MEMORANDUM

To: FILE
From: Shukria Wiar
Subject: Application ID: 2013-181
Date: 8/2/2013

Comments Submitted by: David Senus/Civil Engineering on 8/2/2013

DRAWN: CMW DATE: JULY 2013
DESIGNED: RJW SCALE: 1" = 10'
CHECKED: RJW JOB NO. 3215
FILE NAME: 3215-PHOTO
SHEET C-4.0

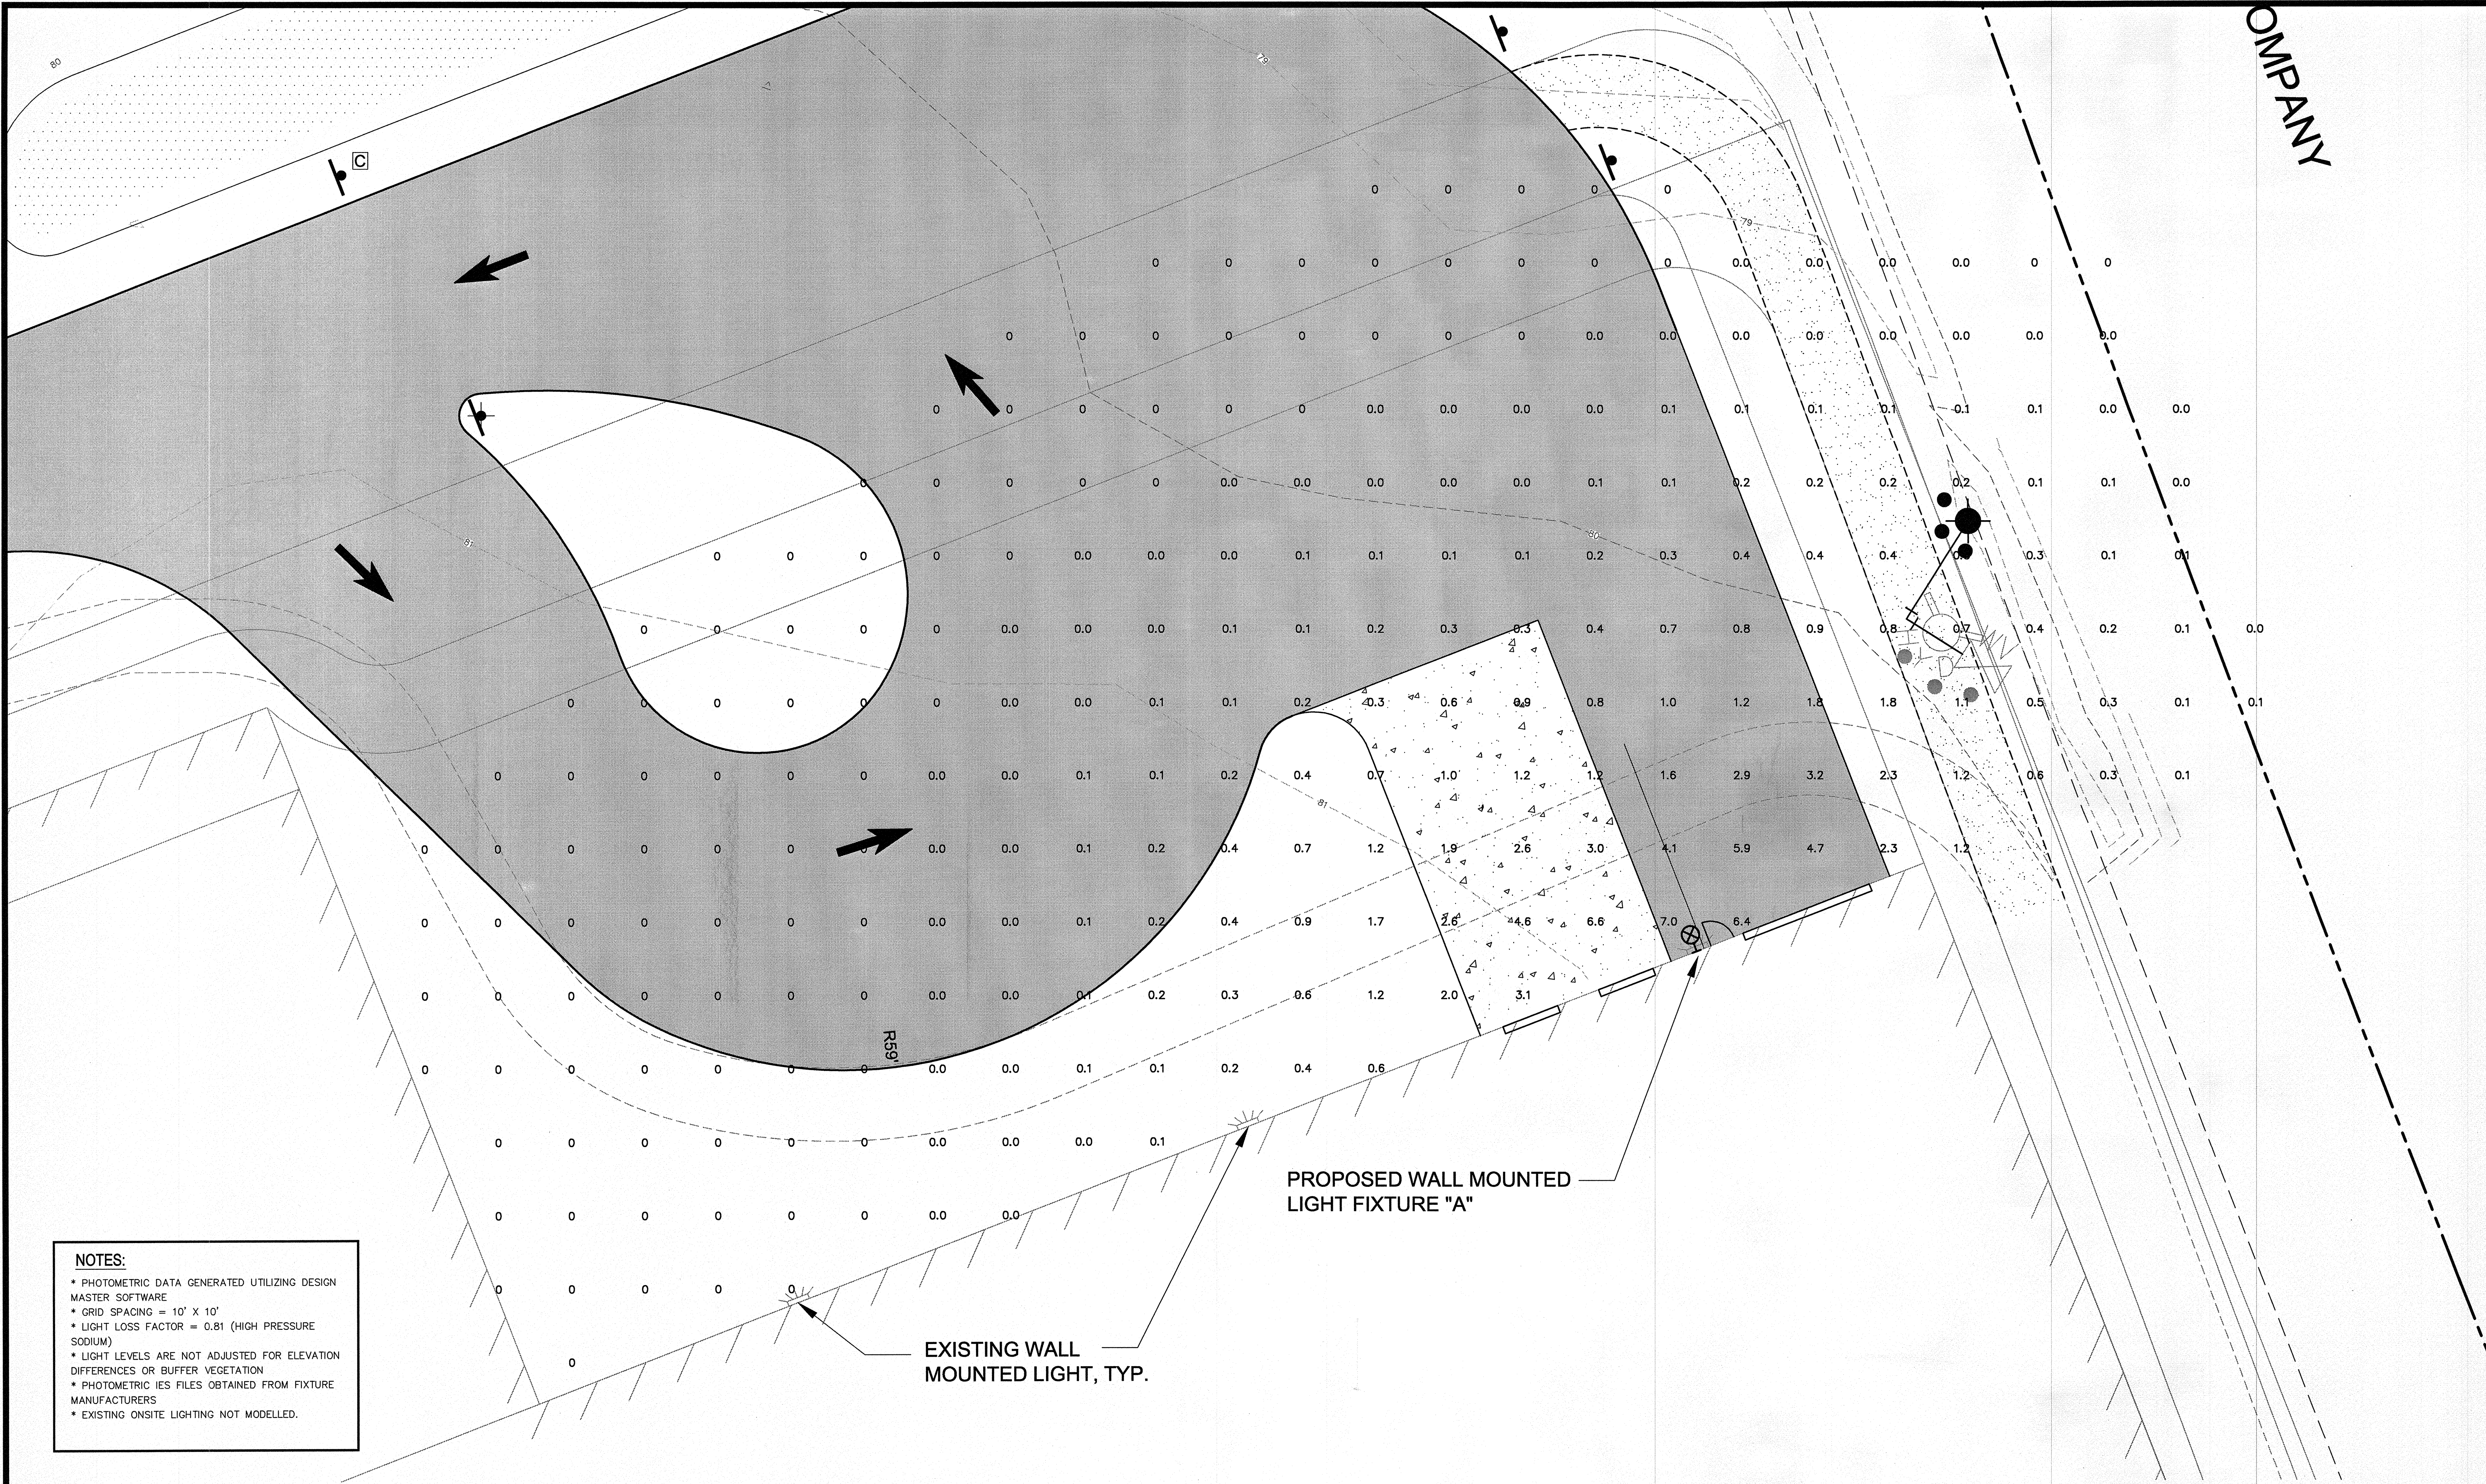
1. Will there be any new lighting being proposed? If so, please provide lighting catalogue cuts and show location on site plans. We will also need photometric plans.
2. Is there any options to decrease the impervious area as related to this project.
3. The applicant is not proposing sidewalk or curbing as part of this project. Please address how this project is meeting the sidewalk waiver criteria.

AT-1

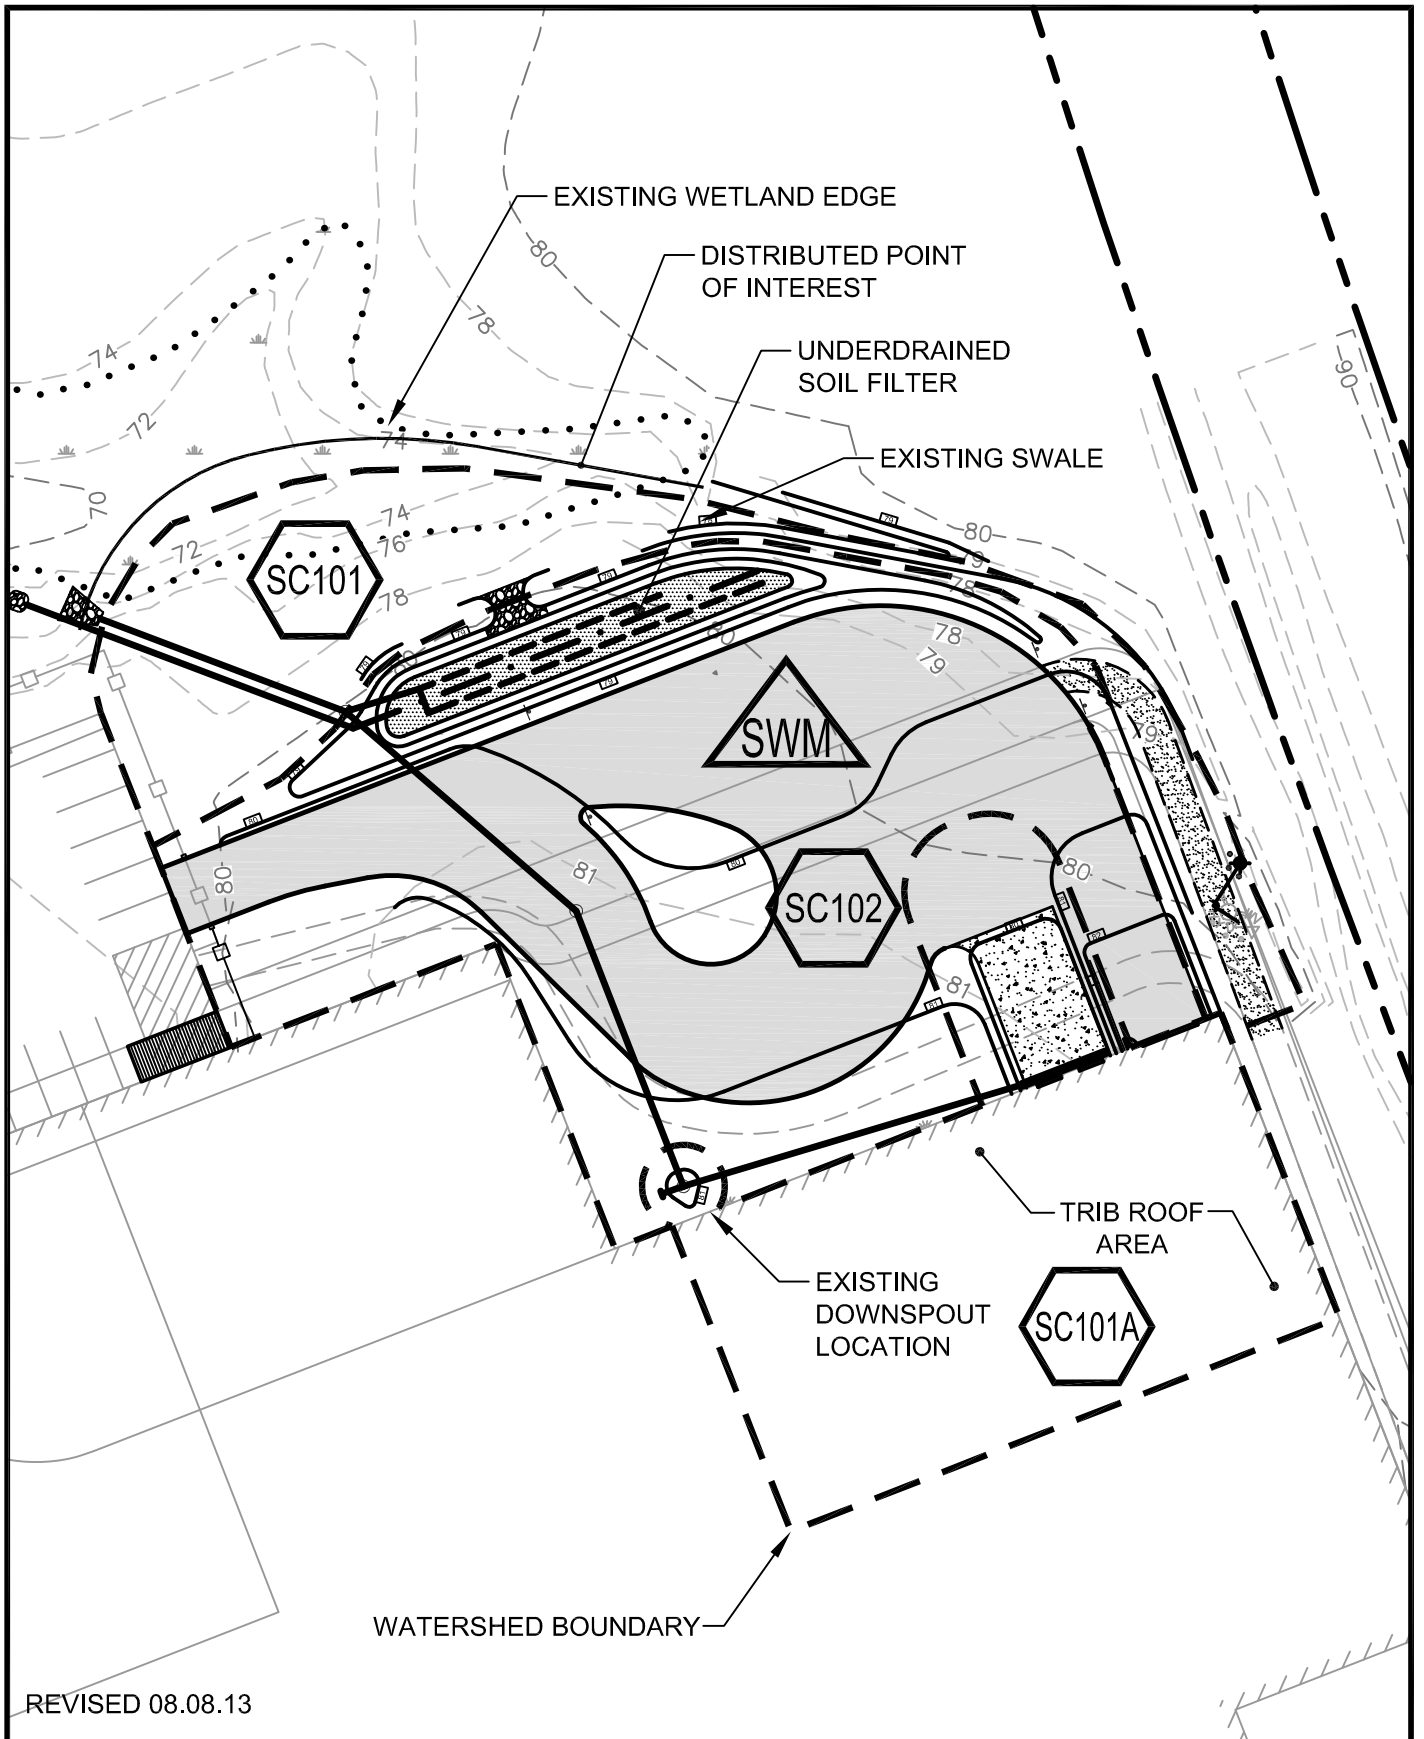
- The applicant should provide auto-turn template graphics that support the proposed pavement area. It is suggested that pavement area be reduced if it can work from a truck circulation perspective.
- The project is proposing a 22-foot wide circulation aisle which is narrower than the typical 24 foot requirement. Given the location of this drive, I find it to be acceptable.
- I will coordinate the evaluation of sidewalk needs along property frontage with DPS staff and will provide a response in the future.

WS-2

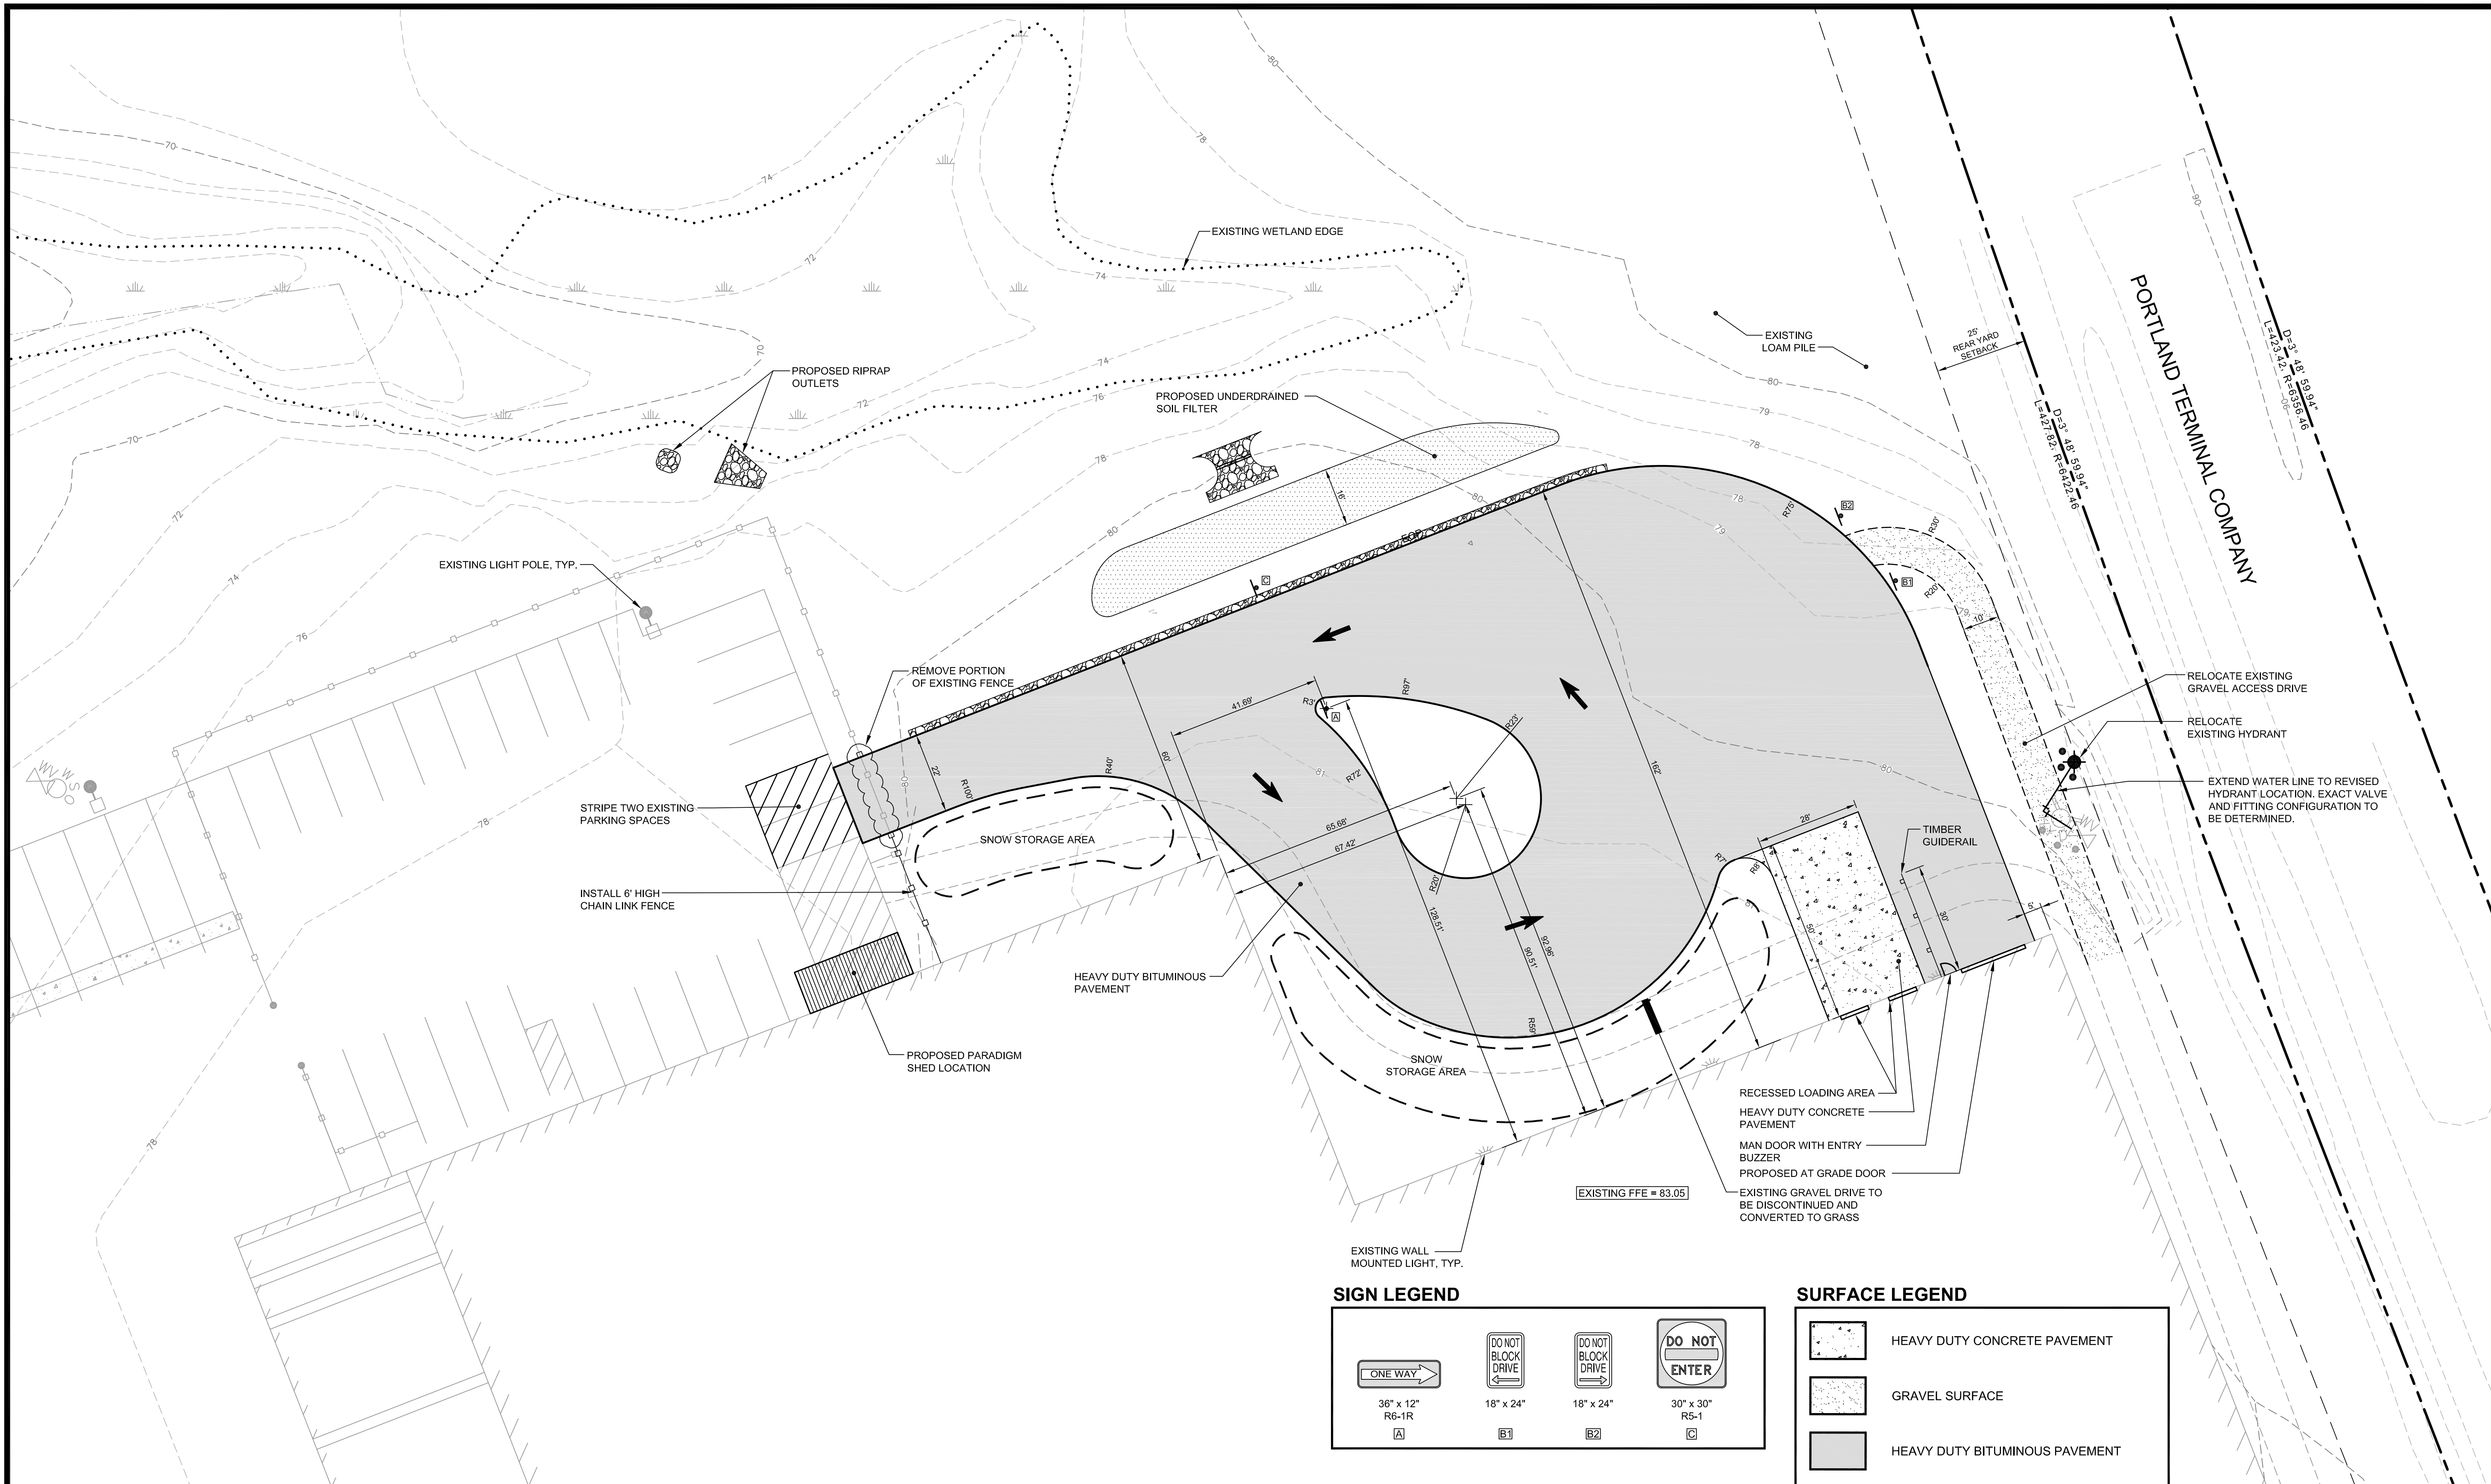
3)Figure WS2 - Post Development Watershed Map: The SC102 and SC101A boundaries do not appear to reflect the extent of the capture area associated with the proposed loading dock trench drain. If the capture area for the trench drain is greater than currently reflected on the figure, the Applicant shall recalculate the "impervious area treated" number for the project.
